Please ask for: Sian Eggington
Email: sian.eggington@terraquest.co.uk
Telephone: 0121 2341390
Our Ref: BR/123/20/HH
Your Ref:
Date: 17th June 2020

Application for Planning Permission for Works or Extension to a Dwelling

Development: Conversion of loft space and new dormers.
Location: 20 Bridorley Close Pagham PO21 3NP

PROPOSED GROUND FLOOR PLAN

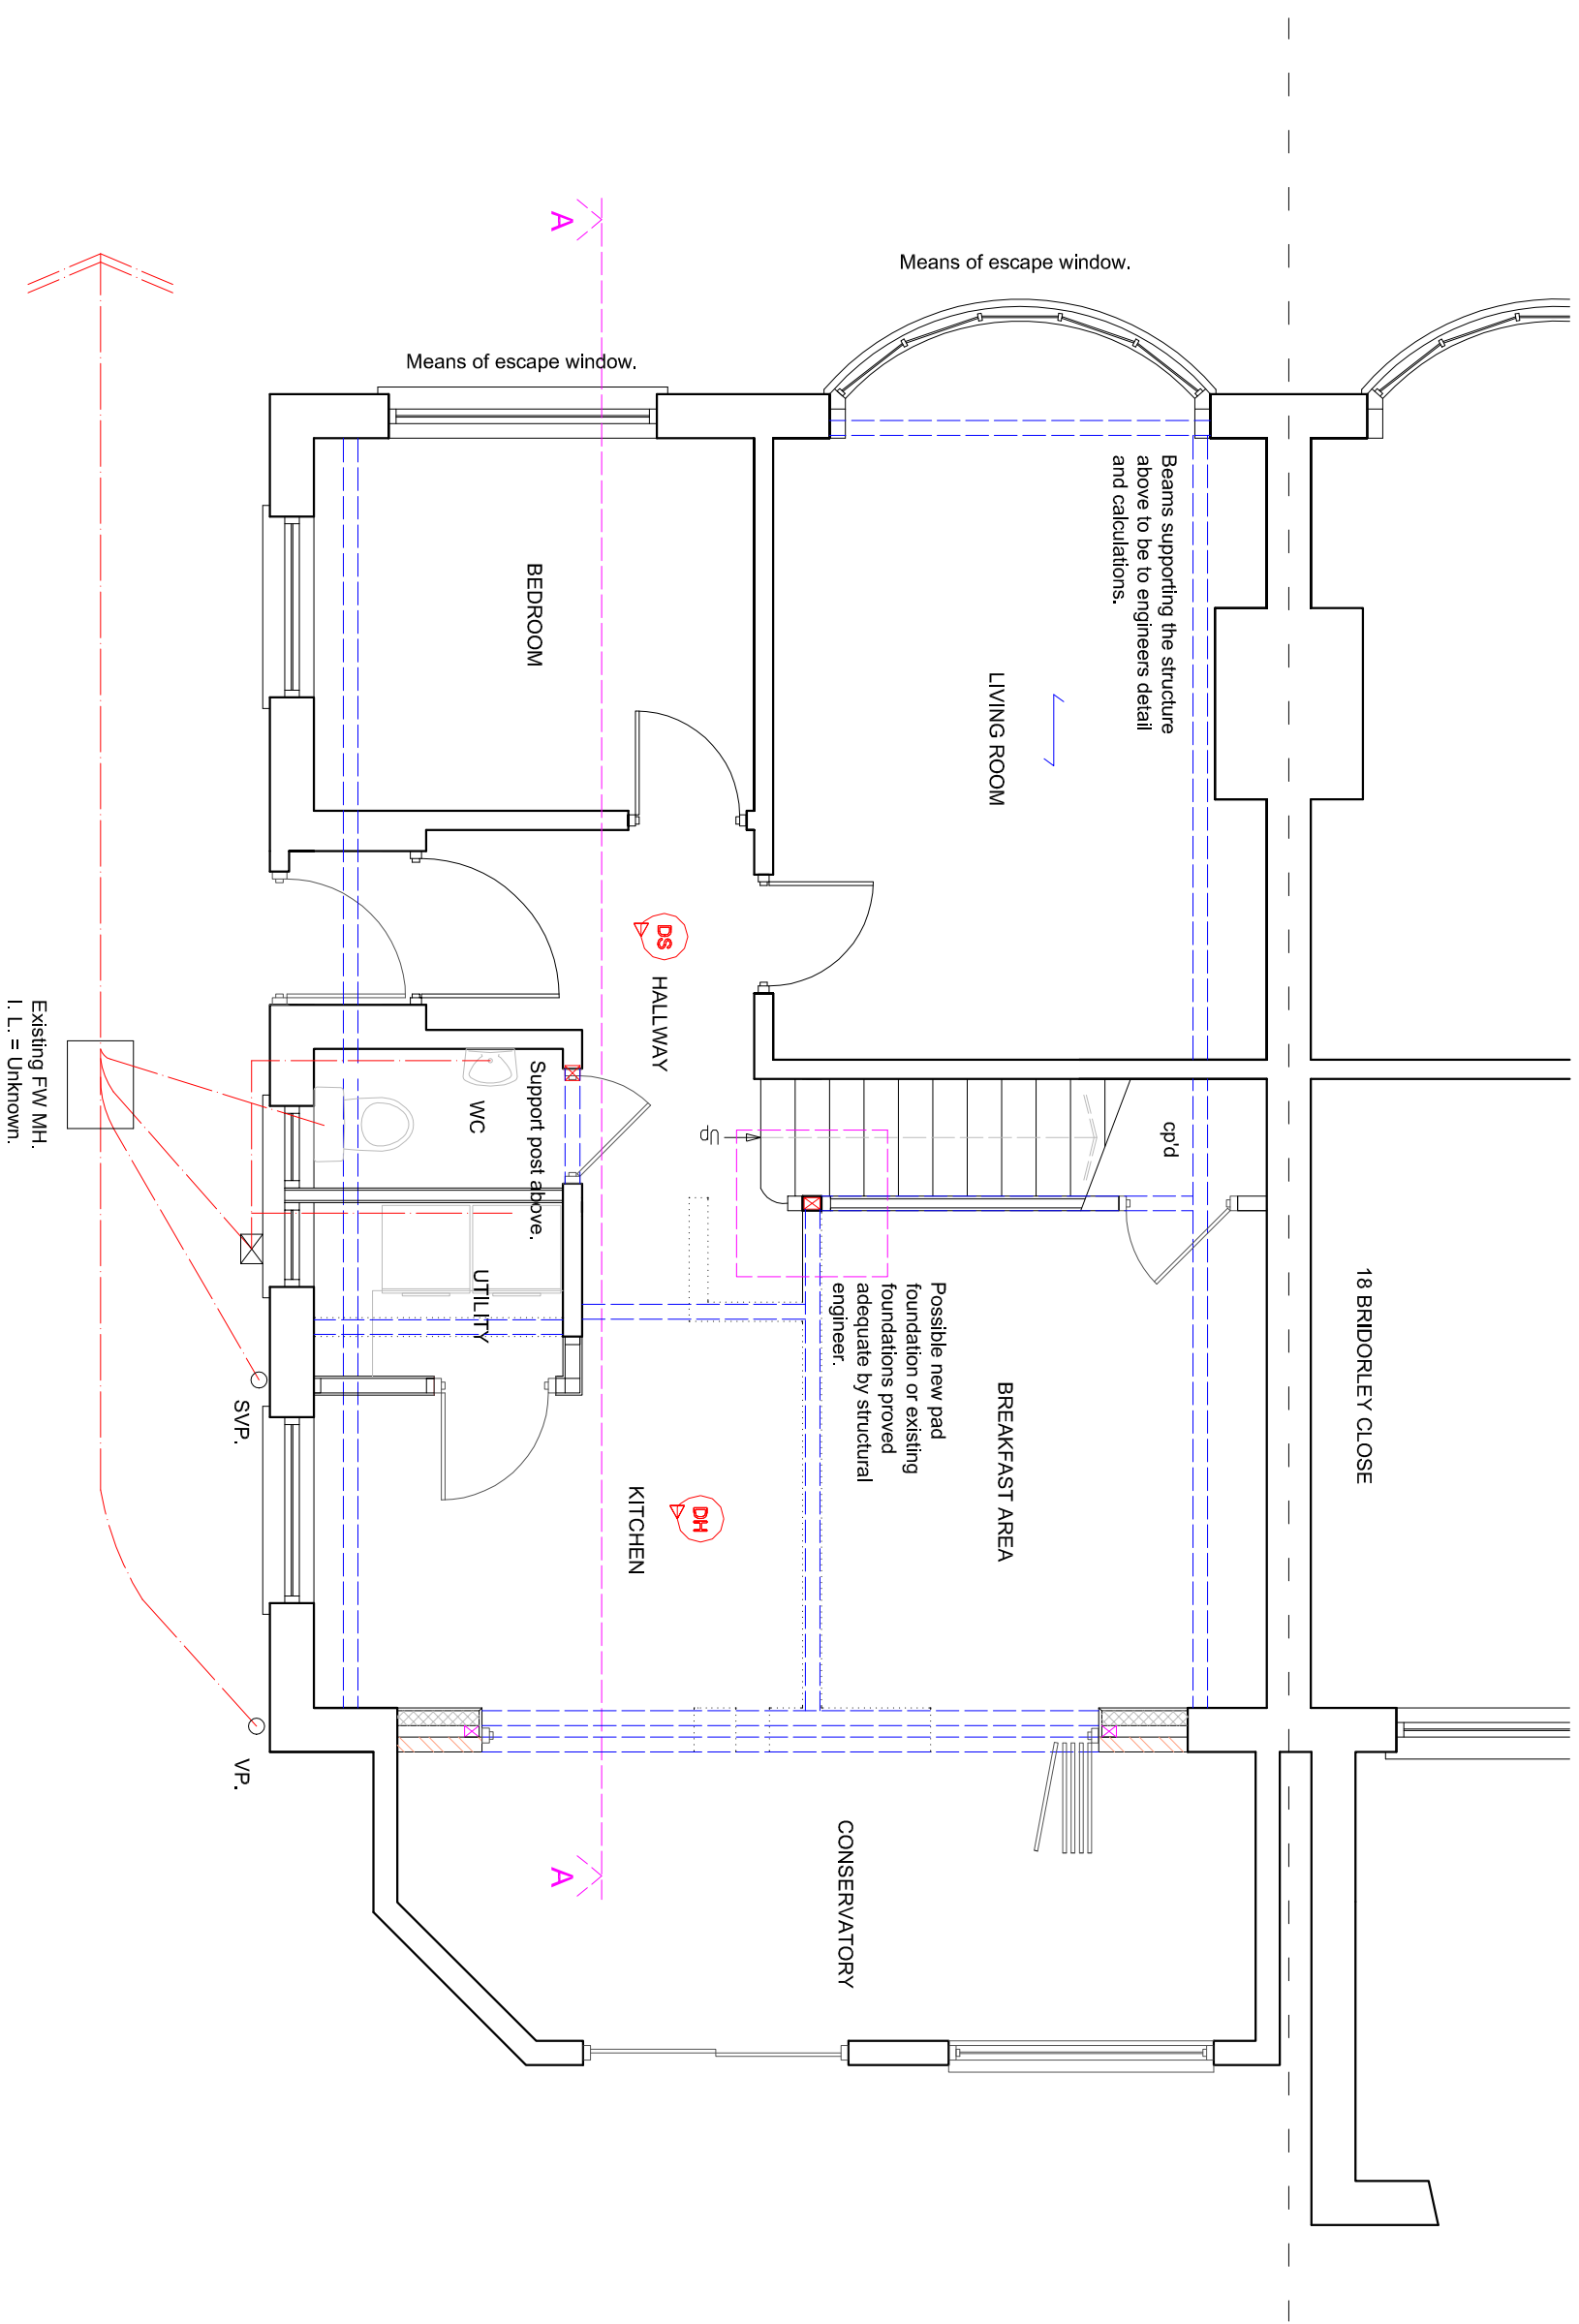
Plan: The windows are inconsistent between the proposed ground floor and side elevation. Please amend.
